**SITE PLAN CONTROL APPLICATION
DELEGATED AUTHORITY REPORT
MANAGER, DEVELOPMENT REVIEW, WEST**

Site Location: 3865 Old Richmond Road

File No.: D07-12-20-0053

This SITE PLAN CONTROL application submitted by Nadia De-Santi of WSP, on behalf of the Anglican Diocese of Ottawa, is APPROVED as shown on the following plan(s):

SITE PLAN

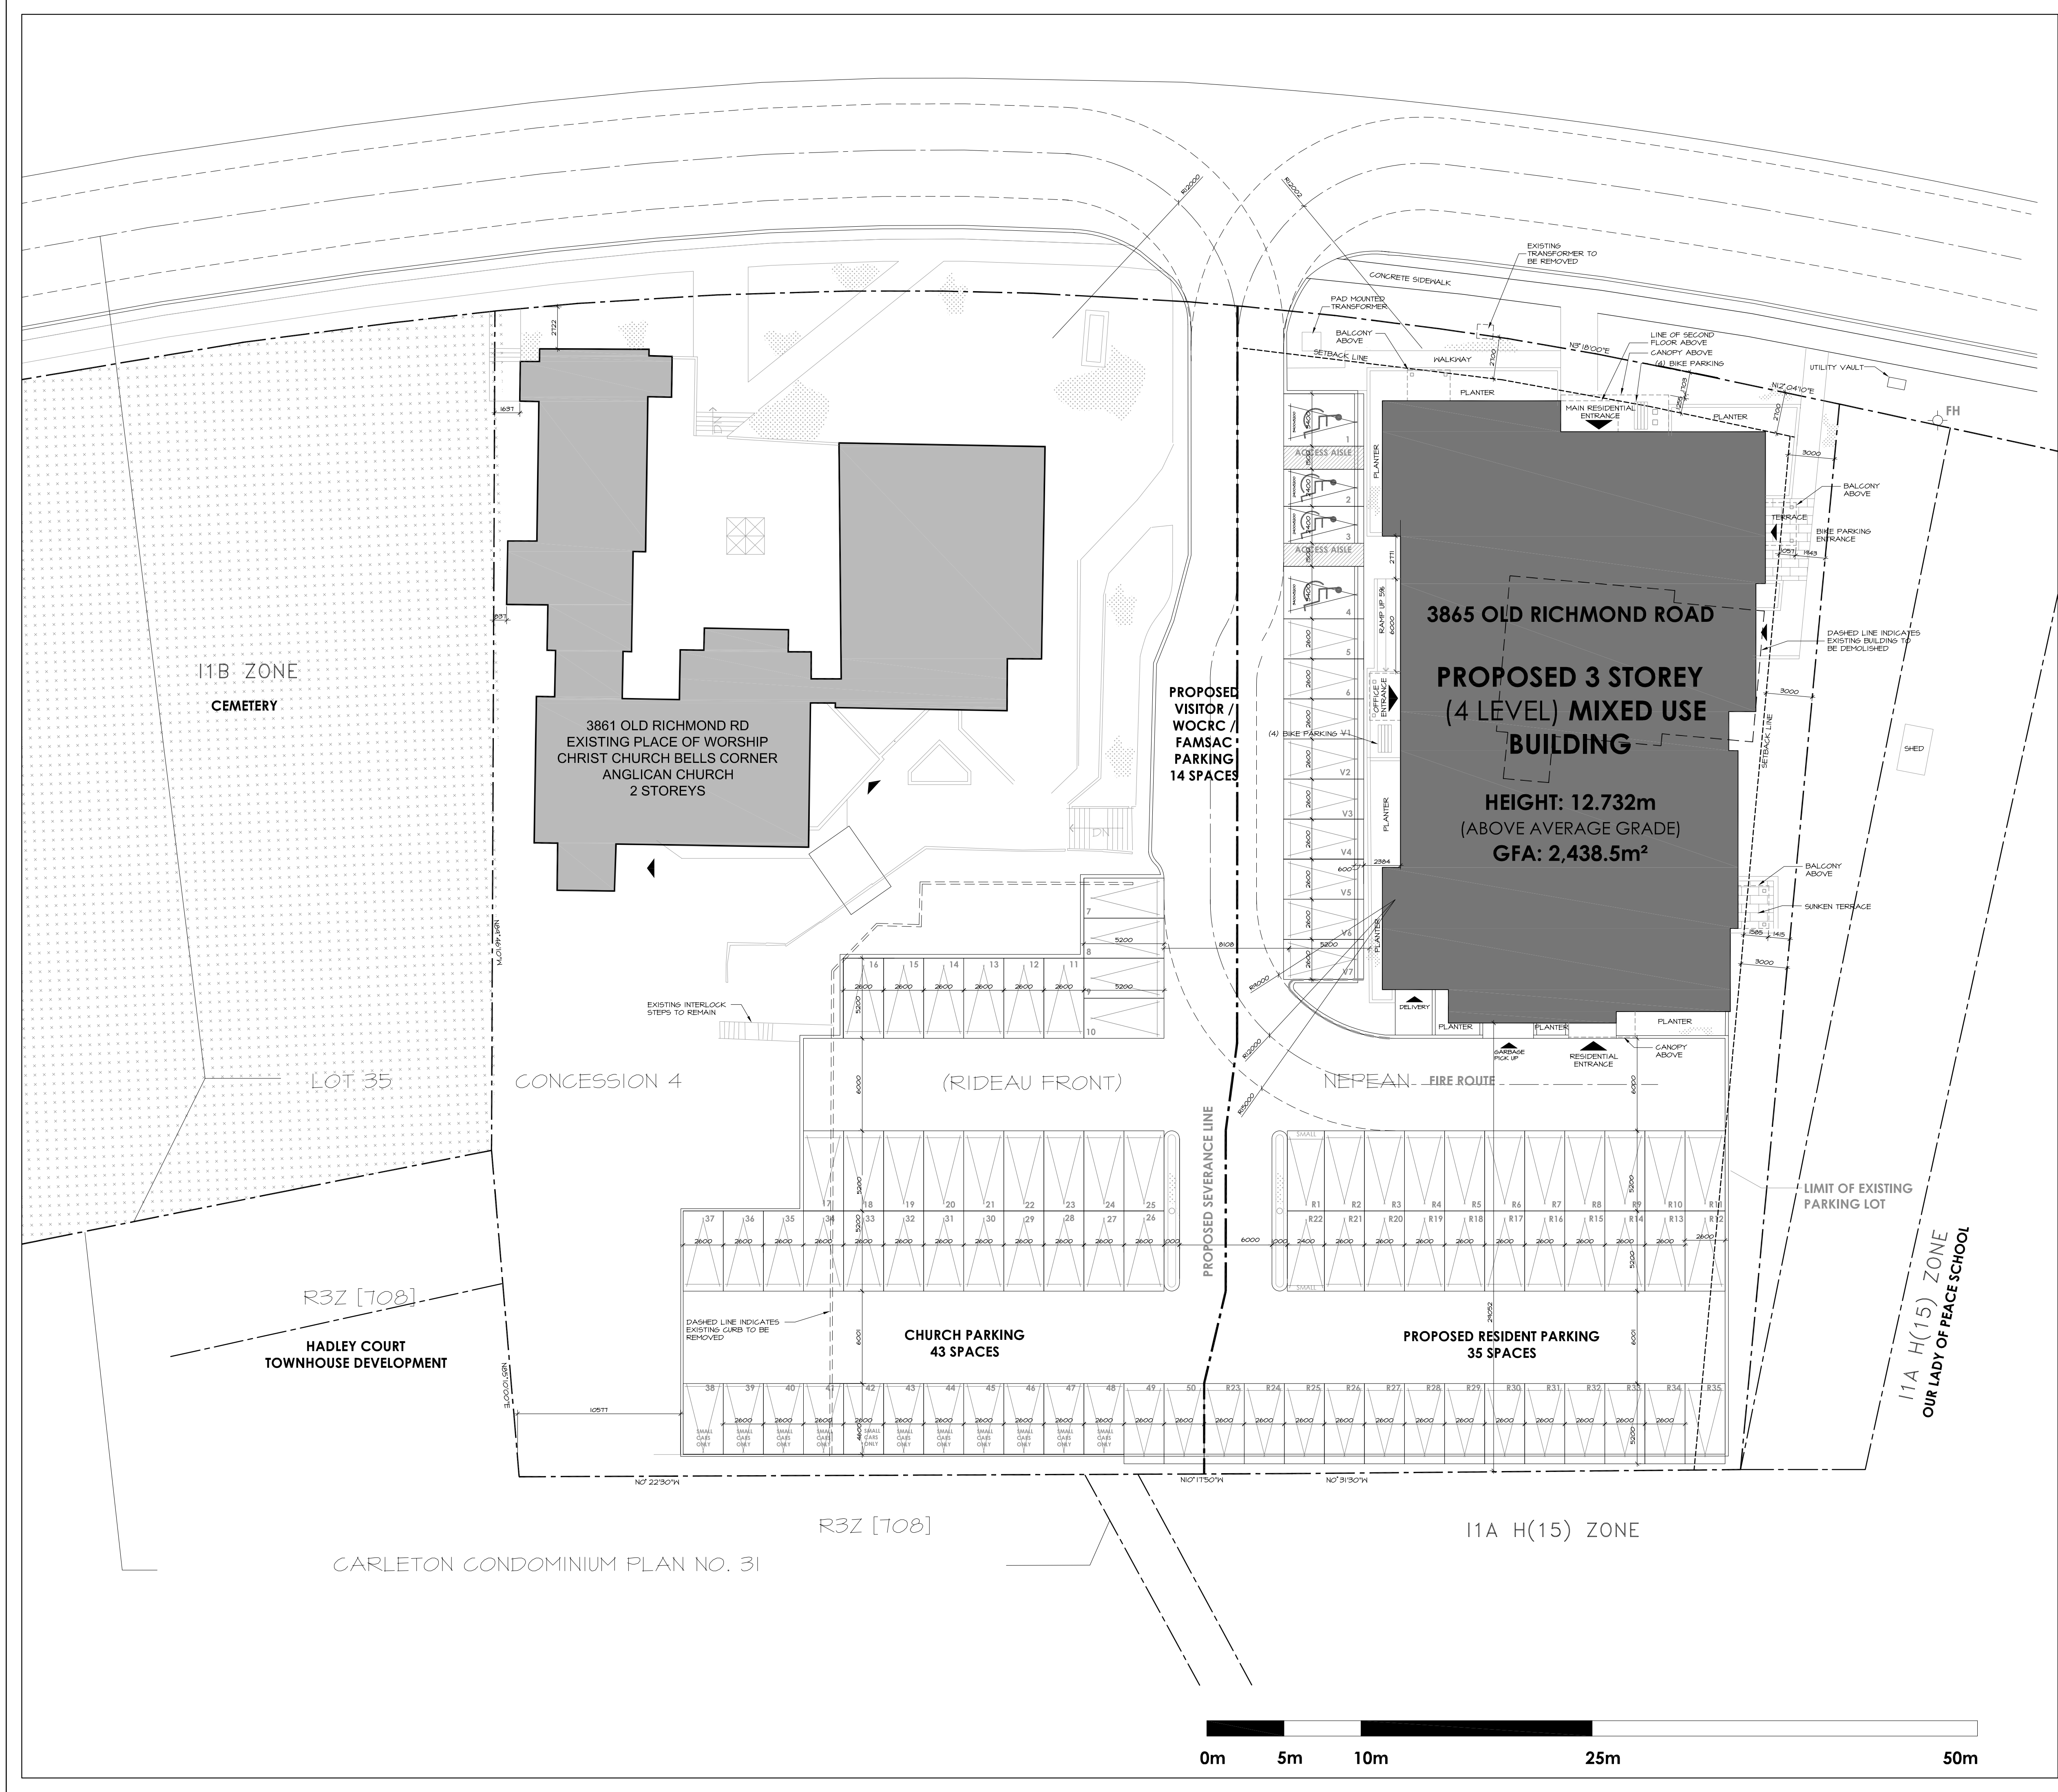
Accessibility Advisory Committee Comment: Looking at The Site Plan it appears that the 2 barrier free parking spaces are corner located and identified as R1 and R22. This parking spaces are also identified as small. The regular parking spaces are 2.6 meters wide while the barrier-free spaces are 2.4 meters wide and located in the residential parking spaces. These two parking spaces may present a challenge for a visitor of residential dwelling or for a potential tenant of the one-bedroom accessible dwelling if the person requires a safe accessible unit. End location barrier free parking space does not necessarily guarantee easy access.

Response: Parking spaces R1 and R22 are not barrier free parking spaces and are not noted as such. The 1000mm wide element to the left of these parking spaces is a curbed island with a light standard on it. See parking spaces 1, 2, 3 and 4 which are shown as barrier free parking spaces (with the conventional symbol). These barrier free parking spaces are provided per AODA standards.
